From: N Adames [REDACTED]
Sent: 23 September 2019 15:43
To: Simon Davis <Simon.Davis@arun.gov.uk>
Subject: letter of objection to planning application ref Y/77/19/OUT

1 However these applicants wrap up their proposal, in what format, the access/exit into the Hamlet of Flansham is extremely dangerous and inadequate, and will certainly lead to serious accidents because the sightlines are too short. I have lived in Flansham all my long life and the driveway in question, was really quite unsafe before the new roadworks were built for the A259 and its roundabout some eight or so years back.

Visibility Splays
and Swept Path Analysis

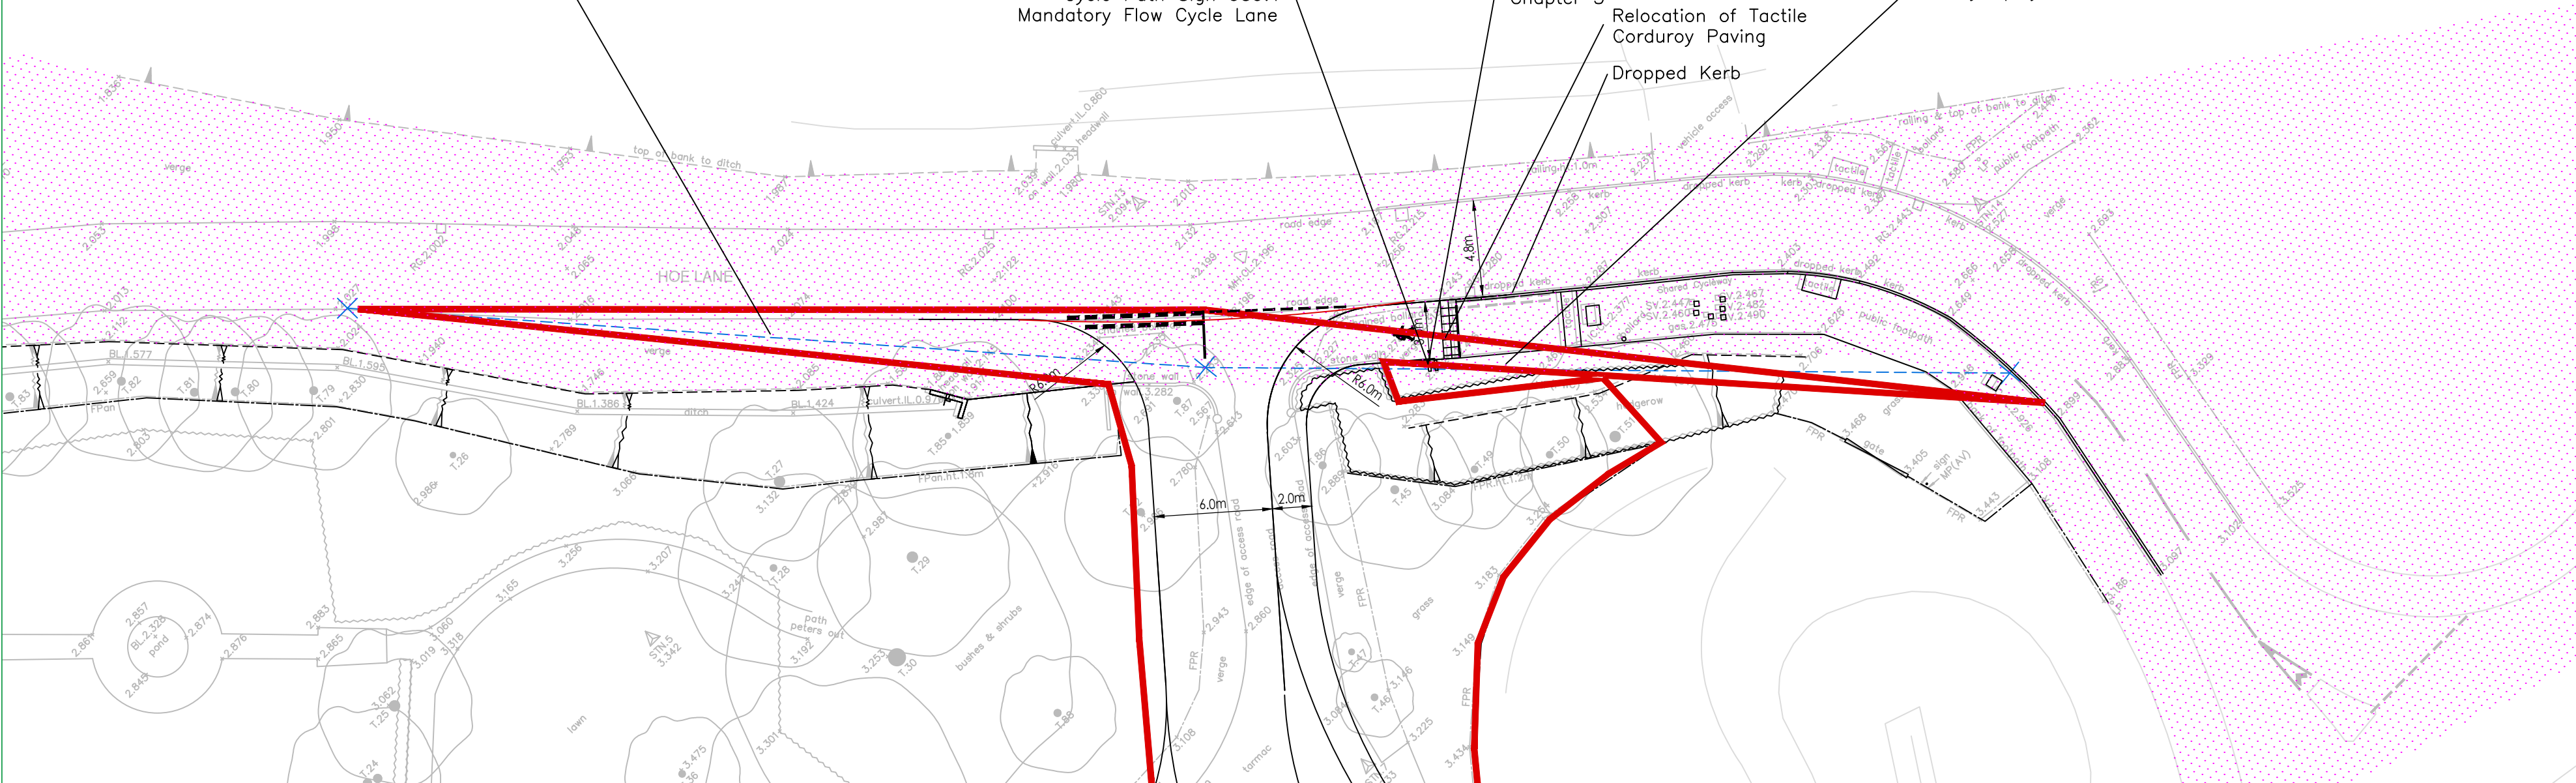
in earlier days there was a straight lane of perhaps ninety to a hundred yards to the main road , and Bonhams owners only had one car; now with the new roundabout and the very poorly designed access in

place of the original, there is a clear run of about thirty five yards before leaving (or entering) Flansham, so you meet a very narrow bend, where two cars are already unable to pass safely.

With impatient drivers, and new traffic coming out of the proposed development, the chances of accidents are multiplied to a quite unacceptable level.

The only possible solution to this dilemma would be for a new entrance to be built into the area on the roundabout between the A259 west wards and the Flansham entrance. There is not a great deal of room but it would certainly be a lot safer than what is being proposed. Needless to say this idea has been rejected by the applicant, presumably due its higher cost. But what cost a life?
